**From:** Caitlin Cameron  
**To:** Fraser, Jean  
**Date:** 6/17/2015 10:34 AM  
**Subject:** Re: Fwd: Master Signage Plan

The master signage plan will need to be revised to reflect the following B-7 Design Standards (Standard E-16 Appendix 4):

Drawing No.: 3 of 5

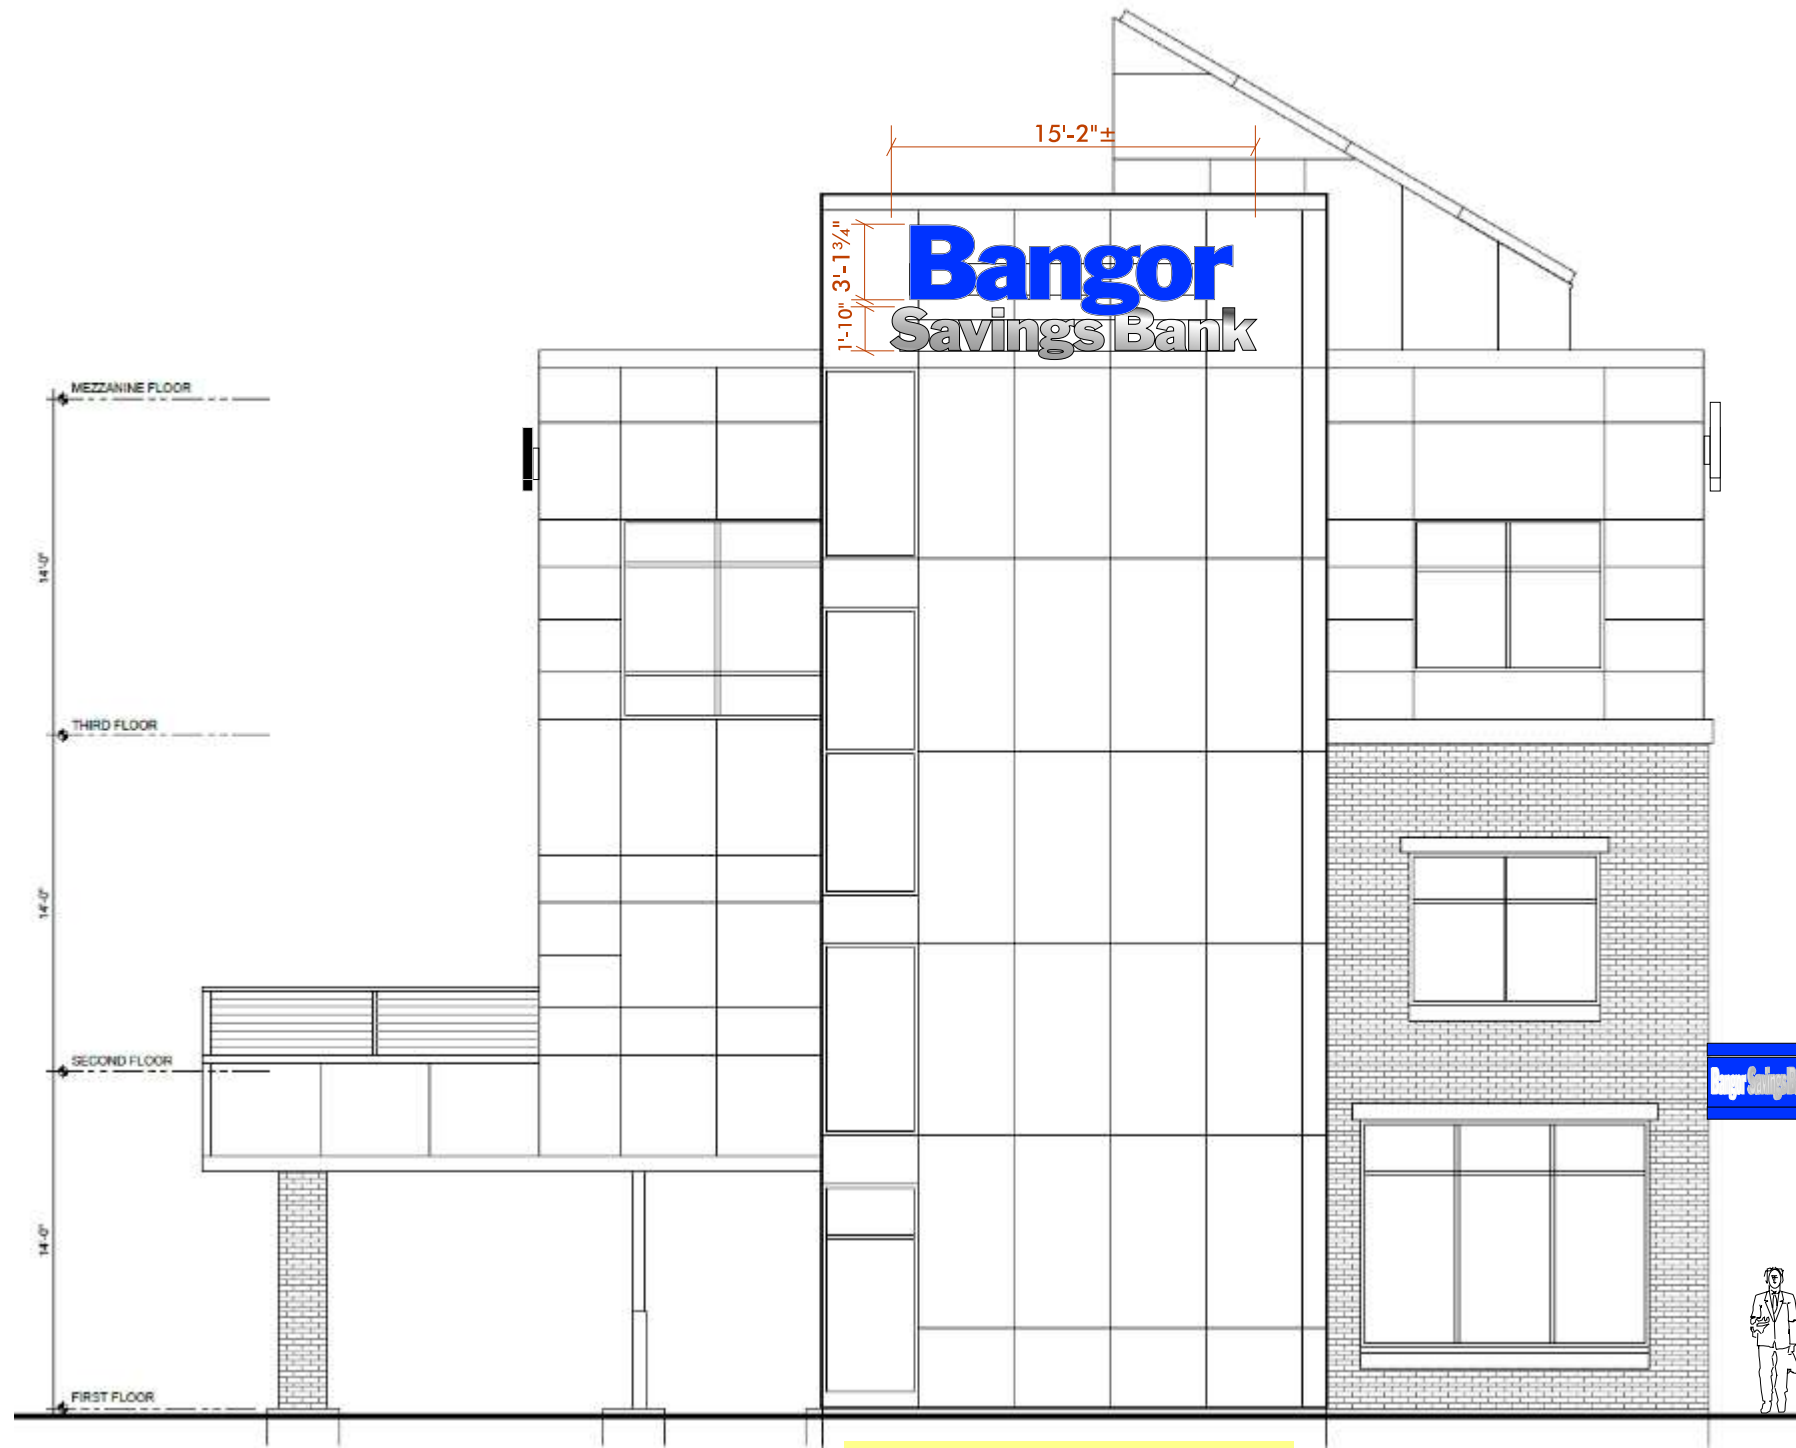
- Each building may have two (2) signs at the upper level - four (4) are proposed
- Each building may have one (1) sign per storefront tenant at the pedestrian level - two (2) are proposed
- Acceptable forms of internal illumination include halo-lit signs and die-cut metal sign panels that illuminate individual letters and symbols only. Internally illuminated plastic face, box-type, or individual plastic letters shall be prohibited.
